WEST SUSSEX COUNTY COUNCIL CONSULTATION

TO:	Arun District Council FAO: Mr S Davis
FROM:	Highways, WSCC
DATE:	17/08/2018
LOCATION:	Land to rear of Woodgate Farm, Hook Lane, Aldingbourne, PO20 3SS
SUBJECT:	AL/64/18/DOC Application for approval of details reserved by conditions imposed under planning permission AL/75/14/OUT relating to condition No.4 (Surface Water Drainage Details), 5 (Sewer Diversion Details), 6 (Cycle parking), 7 (Parking Spaces) & 9 (Construction Management Plan).
DATE OF SITE VISIT:	n/a
RECOMMENDATION:	☒ Advice ☐ Objection ☐ Modification ☐ No Objection ☐ More Information ☐ Refusal
S106 CONTRIBUTION TOTAL:	n/a

job no:	drawing no:	revision:
17	(01)101	T5

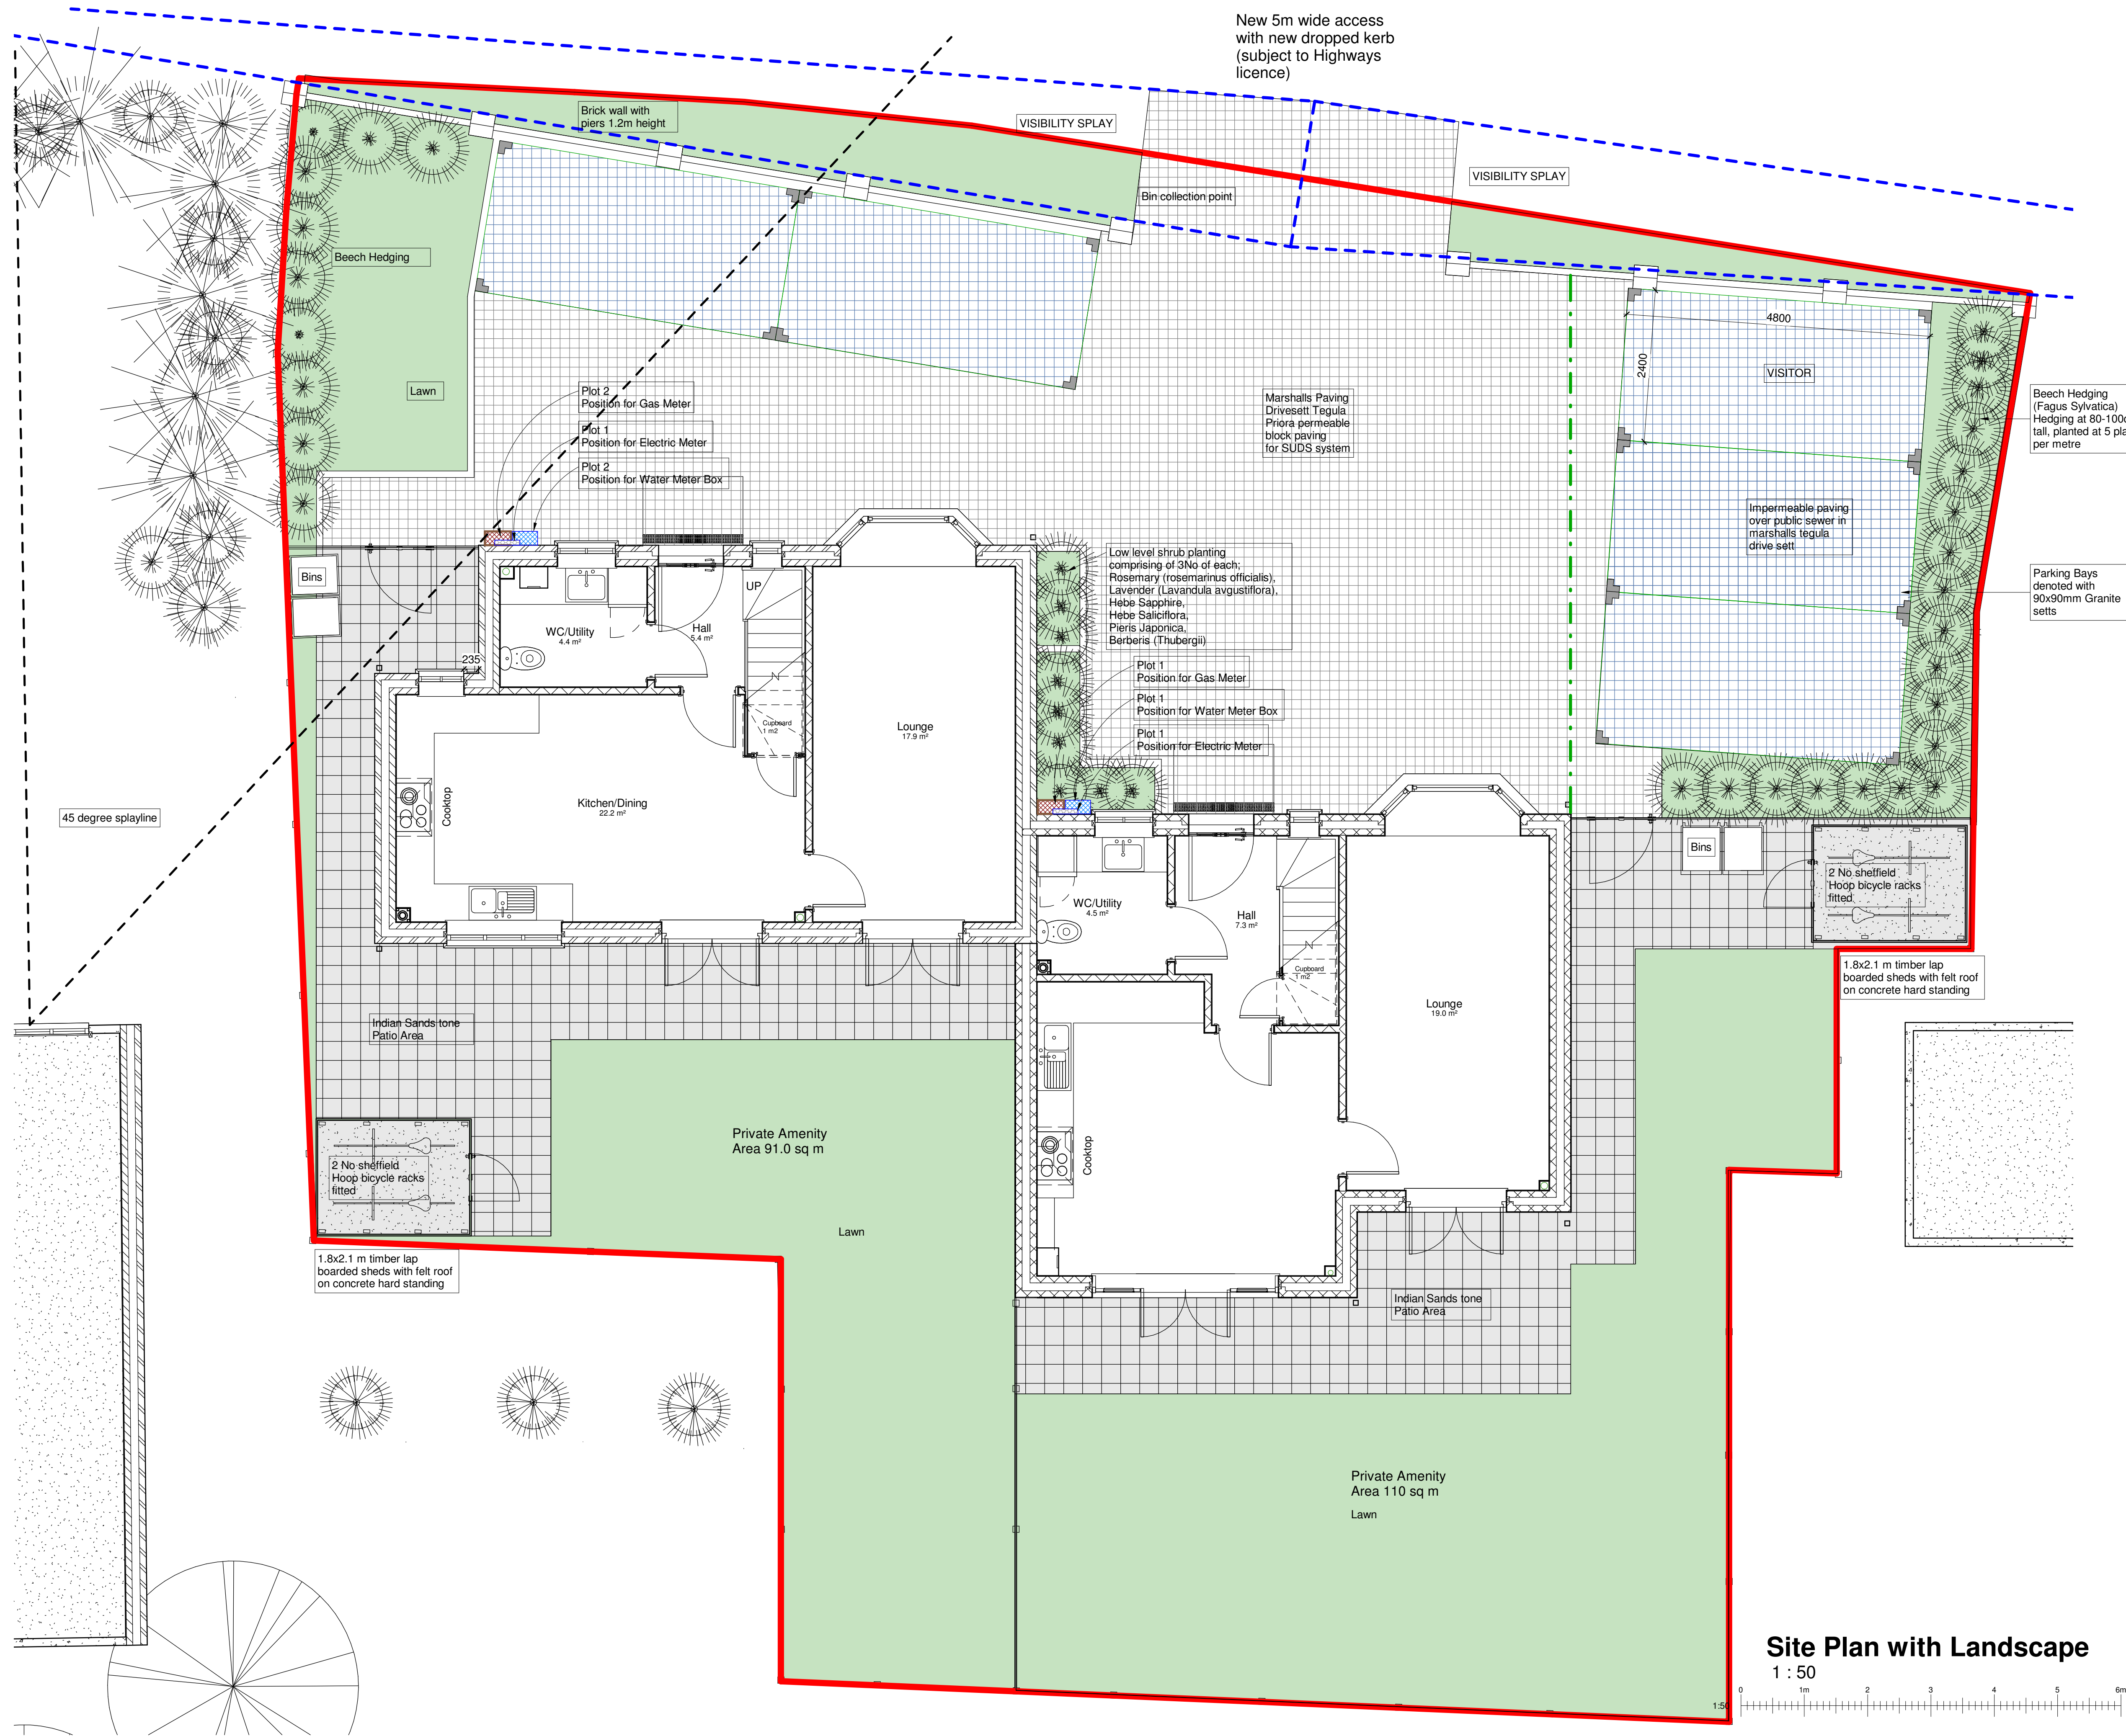
The cycle parking provision has been demonstrated in (01)101 T5 and would be considered acceptable.

Already covered by approval of AL/5/18/RES and demonstrated on (01)101 T5.
